Subject: RE: SSD 9667 - Light Horse Interchange Business Hub, Eastern Creek Response to Submissions

Jemena has taken the opportunity to review the applicants response to submission for the SSD 9667 – Light Horse Interchange Business Hub and we now provide a supplementary response to clarify Jemena’s position (17th September 2019) on the proposed development and its interface with Jemena's existing buried high pressure gas pipeline.

Figure 3.3 – Indicative Sections through Gas Easement

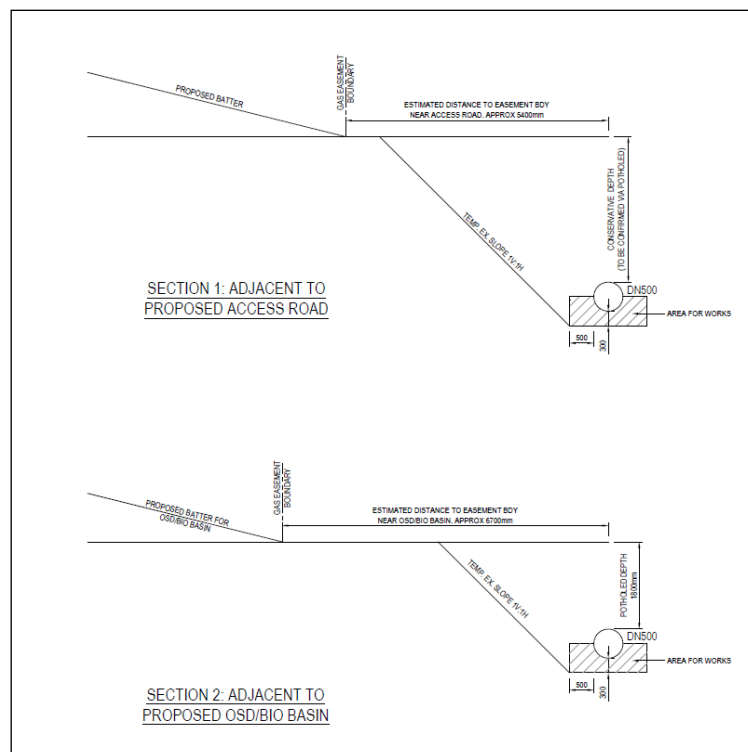
1. the road crossing: There is some loose requirements that load bearing is considered on the Jemena pipeline. Jemena requests that it be contacted and approval sought in order to obtain design and construction requirements for and load bearing slabs over the pipeline and requirements to allow the road to be constructed (i.e. integrity digs, possible re -wrapping of the protective coating of the pipeline etc)
